Application Reference: 2025/0381

Site Address: 116 Ashley Grange, Haigh Lane, Hoylandswaine, Barnsley, S36 7JQ

Introduction: This application seeks full planning permission for raising height of existing boundary wall along Haigh Road (part retrospective)

Ref.	Dwg. No.	Rev.
2025/77	02	B

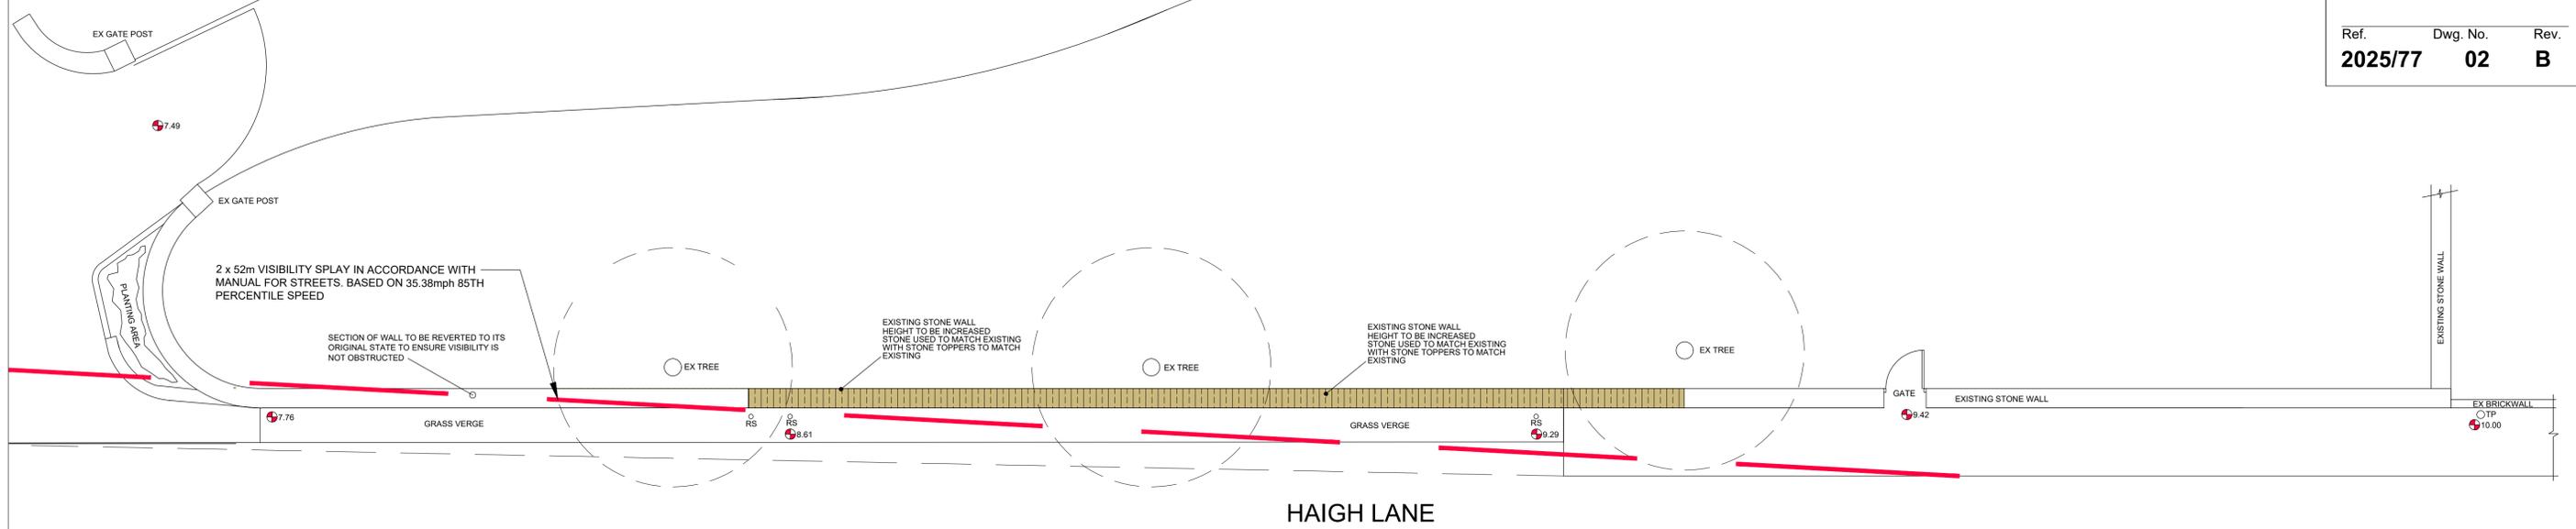
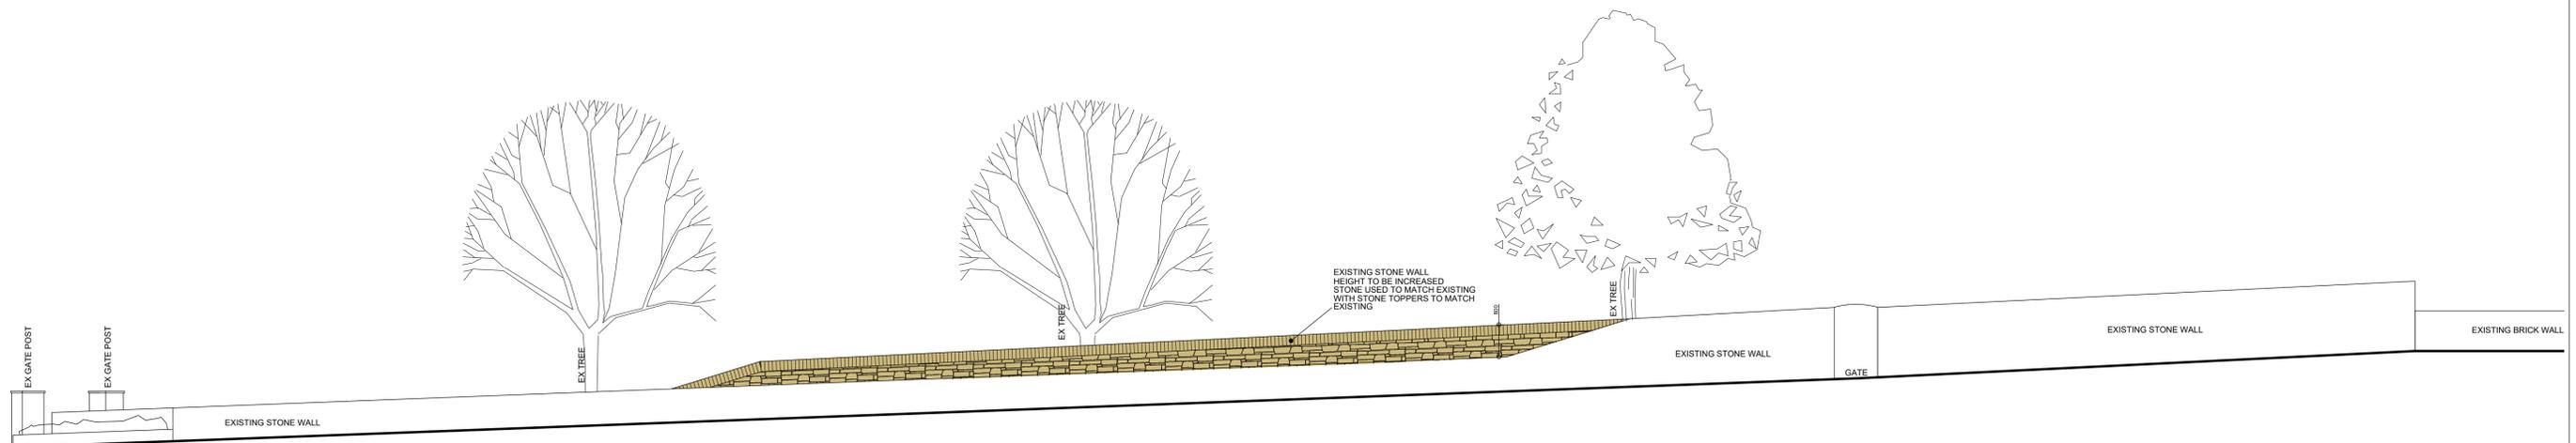
The amended proposal is for works to the application dwelling's stone boundary wall. Following advice from Highways, a reduced amount of the boundary wall would now be increased in height, with any existing unauthorised works being removed and those sections of wall being restored to their original (pre-recent work) size. Of the approximate 75m long section of stone wall, from the gate post at the shared vehicular access to where the stone wall meets a lower red brick wall, an approximate 30m section within the middle extent of the stone wall is proposed to be increased in height. The section of wall to be extended would be around 16m from the where the wall curves into the shared access road, running until approximately 6.4m from the existing pedestrian gate, approximately 25.5m from the end of the stone wall where it adjoins the red brick wall.

This application is part retrospective, with some work already being completed, and some requiring removal. The approved section of wall, as described above, would feature an increase in height, which following an initial incline, would stay relatively constant at circa 0.75m above the original wall height, which stands at approximately 1.05m high. For the approximate last 10m of the wall, closest to the pedestrian gate, the existing wall and additional increase in wall

height both start to incline gently, before progressing to a more significant incline as they adjoin the higher section of original stone wall. In numbers, the base height of the wall starts at around 1.05m but steadily increases in height, especially at last 10m section of wall, to around 2.12m as it adjoins the highest section of the original wall. The additional height increase adds up to 1m of height to the existing wall, but this maximum increase is only for an approximate 3m section of the wall. The remaining wall to be heightened features a lower increase of height, with a significantly lower increase at the beginning and end sections of the wall as it inclines and declines respectively. The combined, final height of the section of wall to be increased would range from 1.05m up to a maximum height of 2.12m, with a midpoint of 1.96m

Initial concerns were raised by Highways in relation to highway safety, mainly due to the high-speed limit of 60mph on Haigh Lane, reducing shortly after the vehicular access point. Highways requested specific assessments to be carried out. After a couple of iterations of these assessments, Highways confirmed the correct information had been received and that “As the visibility splay retained is commensurate with the advice set out in Manual for Streets, Highways DC have no grounds to raise objection to the scheme”. However, this was subject to a condition that “Sight lines to the south-west of the access, having the dimensions 2.4m x 52m, shall be safeguarded at the access junction with Haigh Lane, such that there is no obstruction to visibility at a height exceeding 1m above the nearside channel level of the adjacent highway, In the interest of road safety.”

Following a detailed assessment of the proposal, including the requirement of detailed reports, amendments were required be made to the proposal and remedial work carried out on any work already undertaken. Following these amendments and subject to conditions, there is no objection from Highways, and it would therefore be concluded that there would be no little or no impact on highway safety.

- Highways requested extra information in relation to highway safety, following receipt and review of this information, amended plans were also provided which met Highways approval.
